Charlotte Storm Water
600 East Fourth Street
Charlotte, N C 28202-2844

Rezoning Petition Review

Rezoning Petition #: 20-119

Location of Property: Approximately 9.78 acres located along the north side of Shopton Rd, west of Pinecrest Dr and east of Steele Creek Rd.

SHEET NUMBER  
**RZ-2**

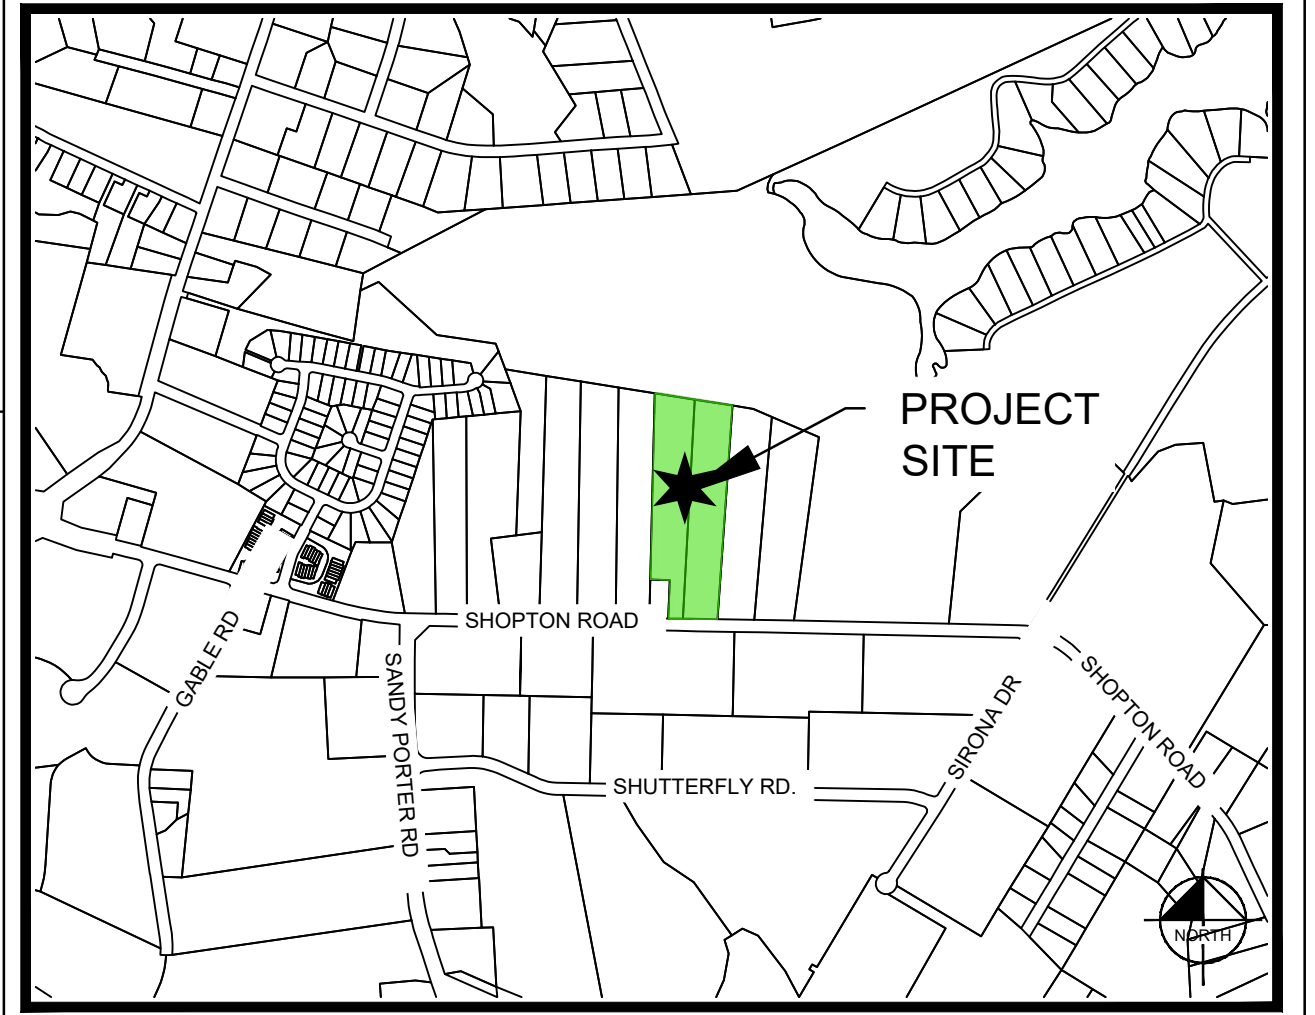
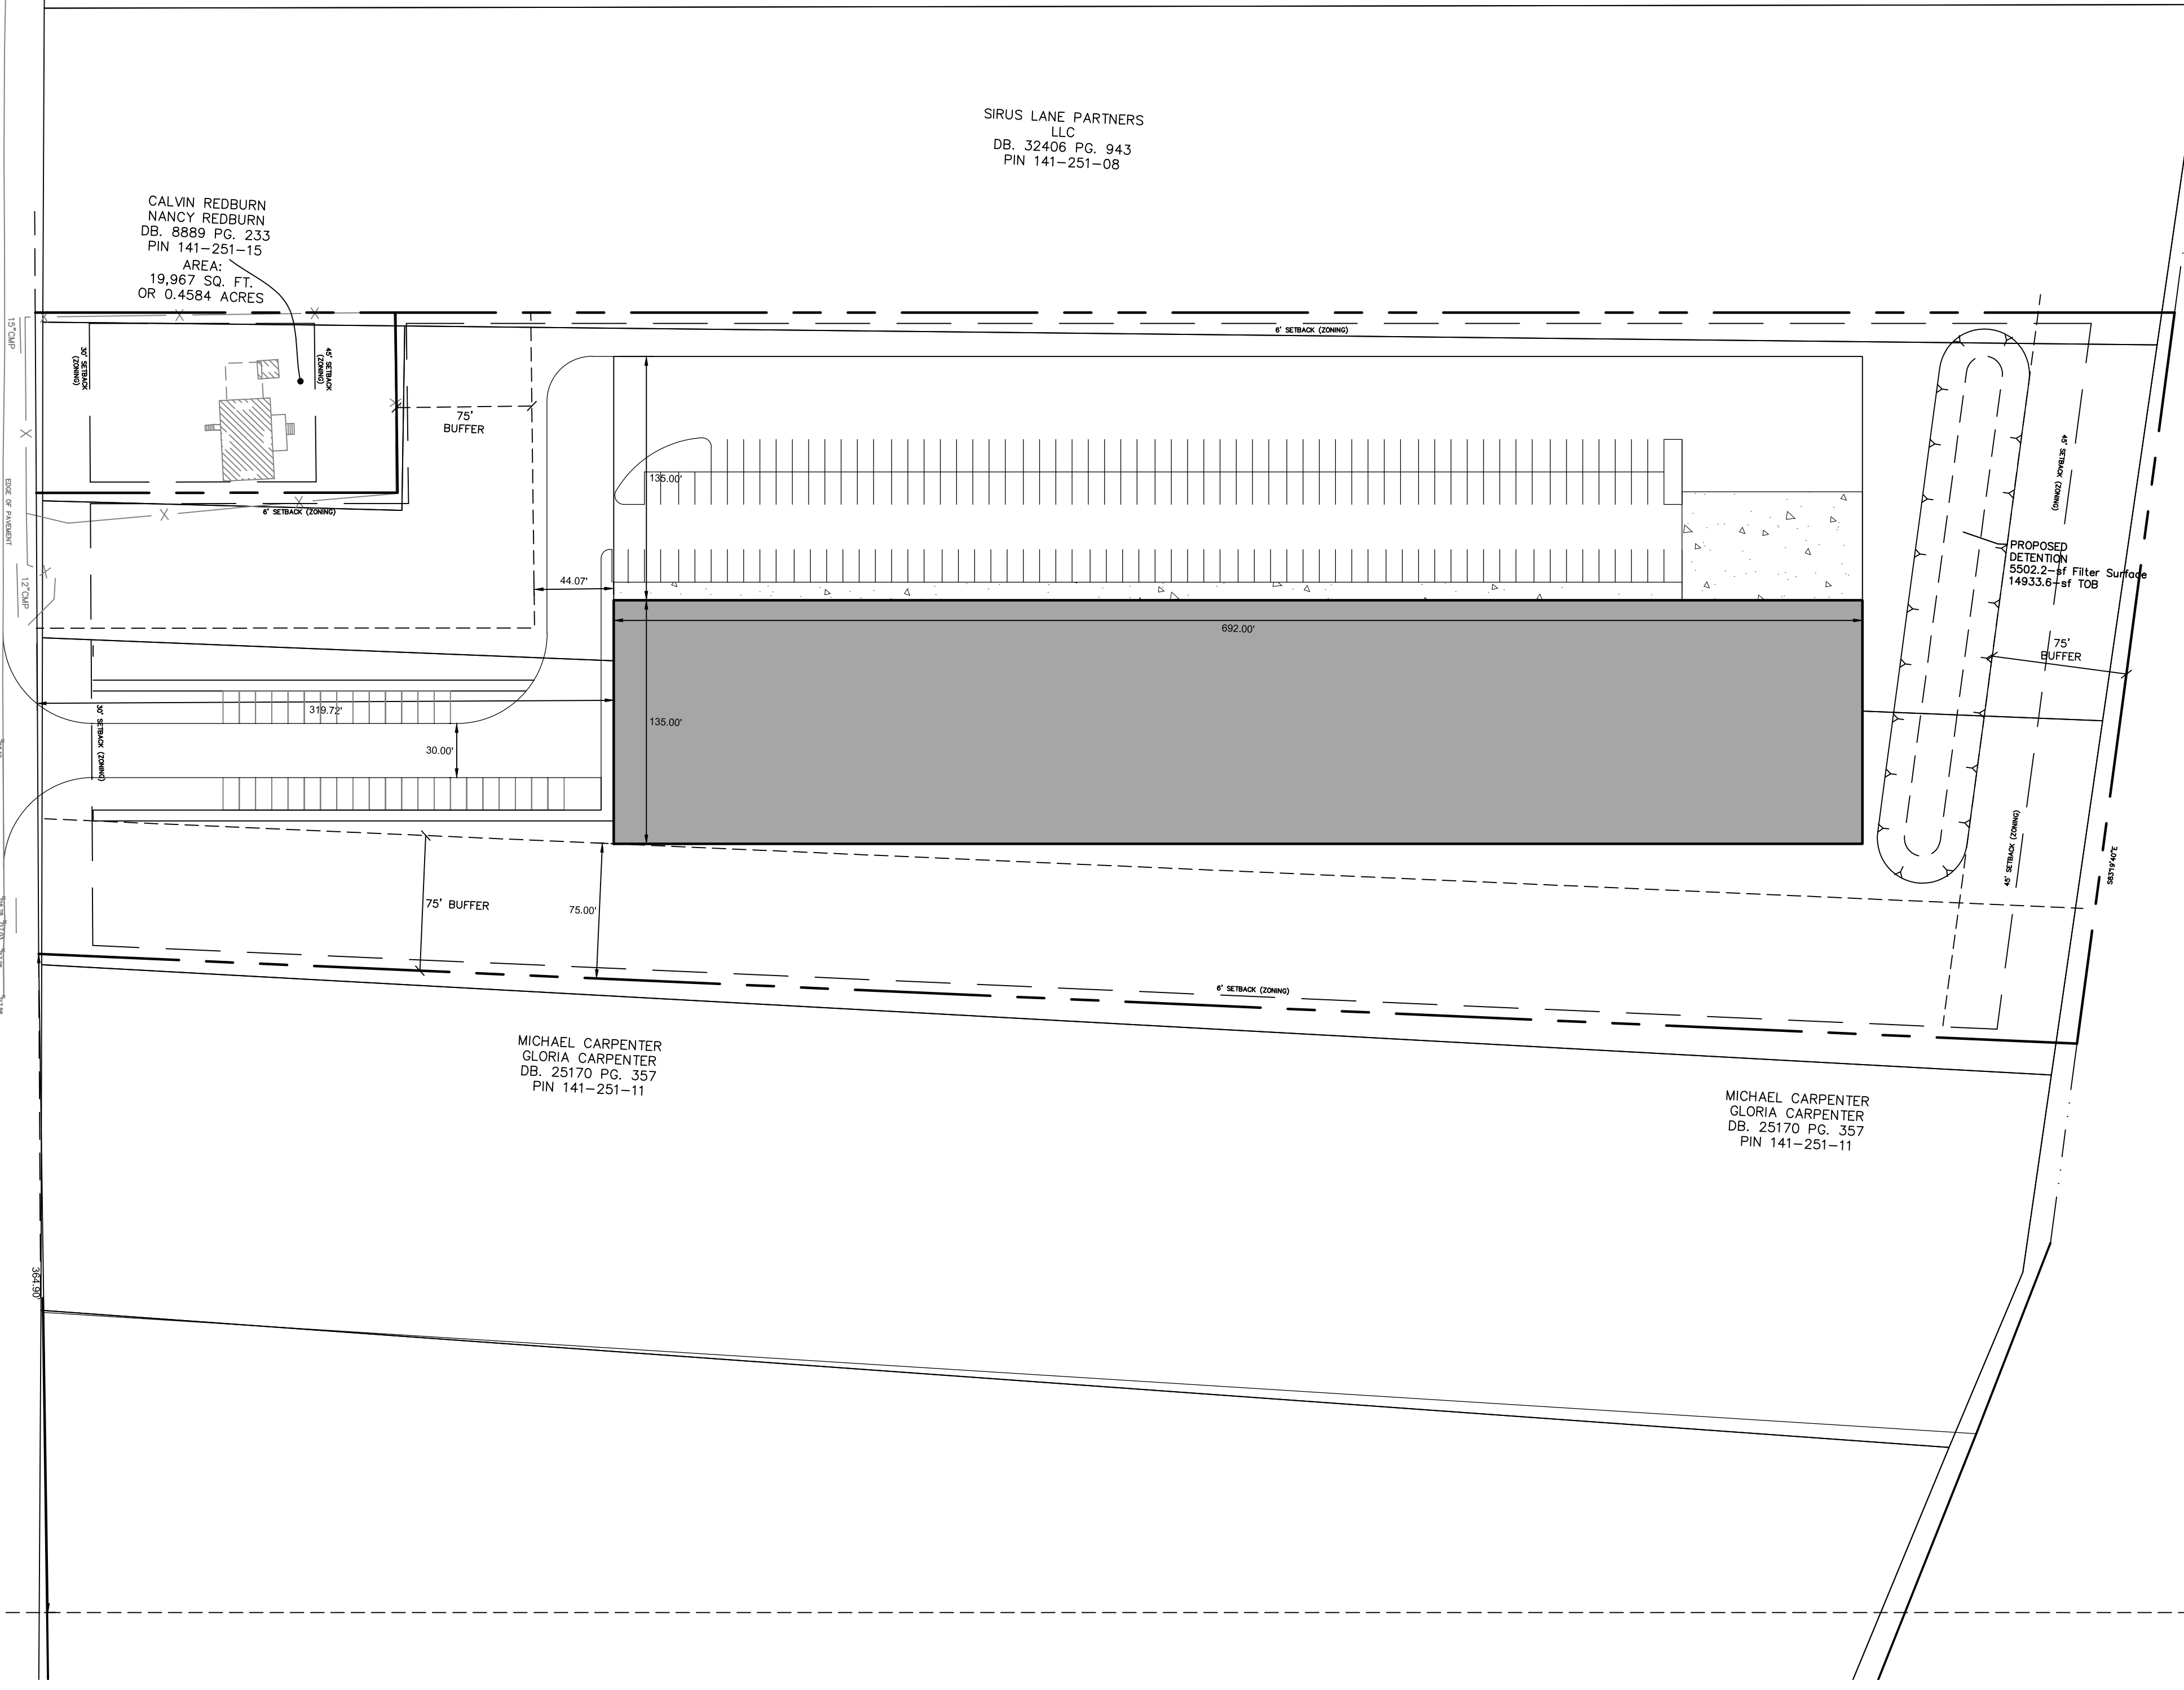
Concerning Storm Water: Please include the following note under Environmental Features:

The location, size, and type of storm water management systems depicted on the Rezoning Plan are subject to review and approval as part of the full development plan submittal and are not implicitly approved with this rezoning. Adjustments may be necessary in order to accommodate actual storm water treatment requirements and natural site discharge points.
